Application Reference: 6/2017/1486/VAR

Proposed development at: Unit 13 Peartree Farm Welwyn Garden City AL7 3UW

Proposal: Variation of condition 1 (approved plans) on planning permission
6/2015/1960/FULL.

SITE/ROOF PLAN

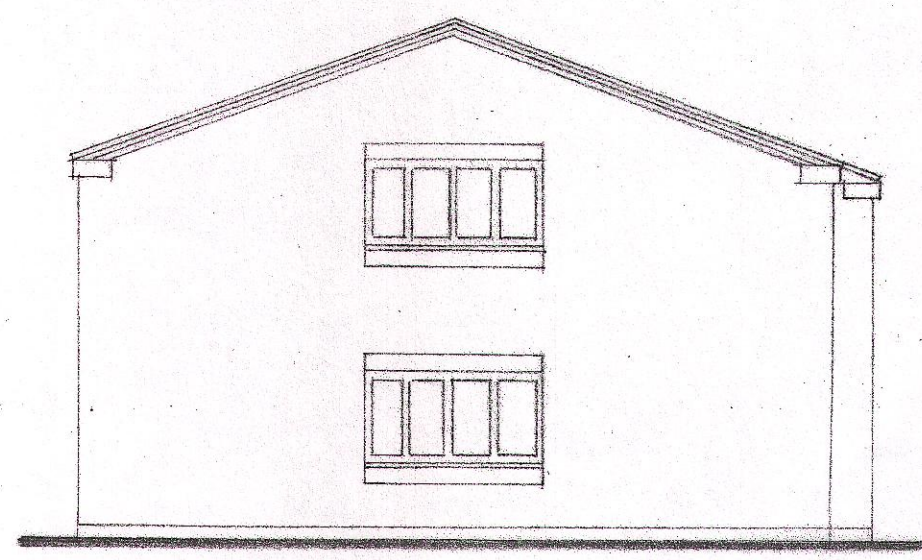
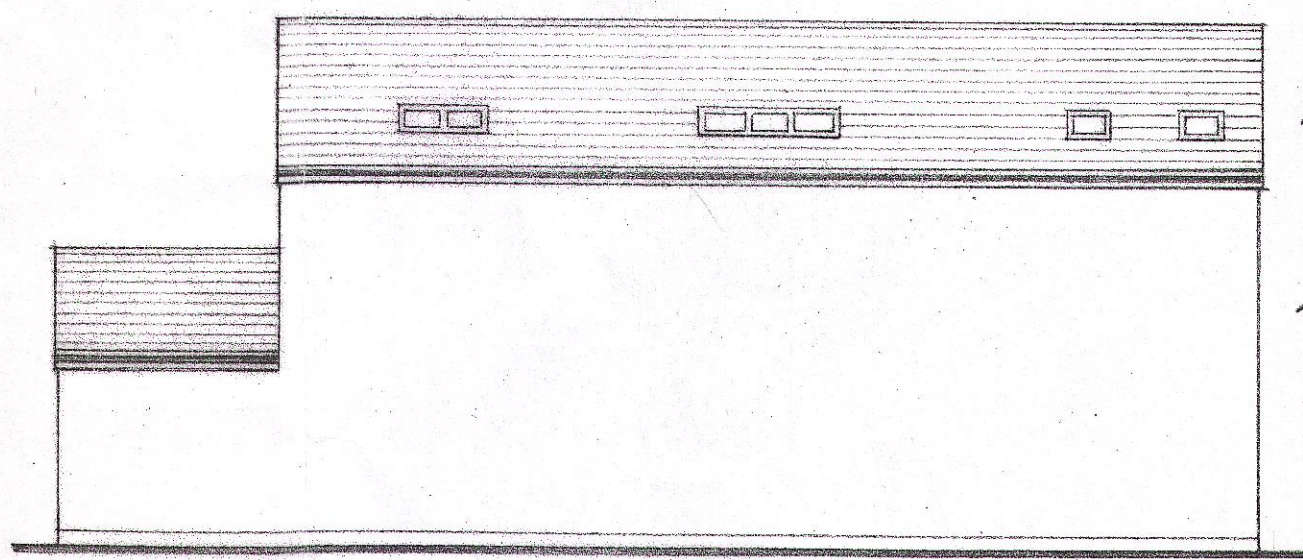
- Whilst I agree with Mr Talbot that there are no windows to the east elevation apart from the roof-lights, there are windows to the north elevation, one of which is at first floor level which will overlook residential properties in Peartree Lane.

- Our main objection is to the raised height of the east (back) and west (front) walls. In the previously submitted plan the view from my garden would have been that of a gabled roof and therefore my amenity would not be obscured. In the revised proposal the view from my garden will be that of a brick wall with a flattened roof.

- The three mature trees are not shown on the drawings submitted therefore it is difficult to see where they are in relation to the proposed building.
- It is also very difficult to see on the plans the separation between the building and our boundary. The proposal mentions a 1m wide footpath to the front and side elevation but nothing about the east elevation.

I also note from the Planning website that the status now reads 'Site visit complete'. Presumably either you or one of your colleagues has visited the proposed site. This visit would not have shown the view from our gardens. Our gardens are 1.5 – 2m below the ground level of Peartree Farm therefore the proposed 7m height will actually appear as 8.5 - 9m in height from our perspective which is why the height of the east elevation and roof pitch are important to us.
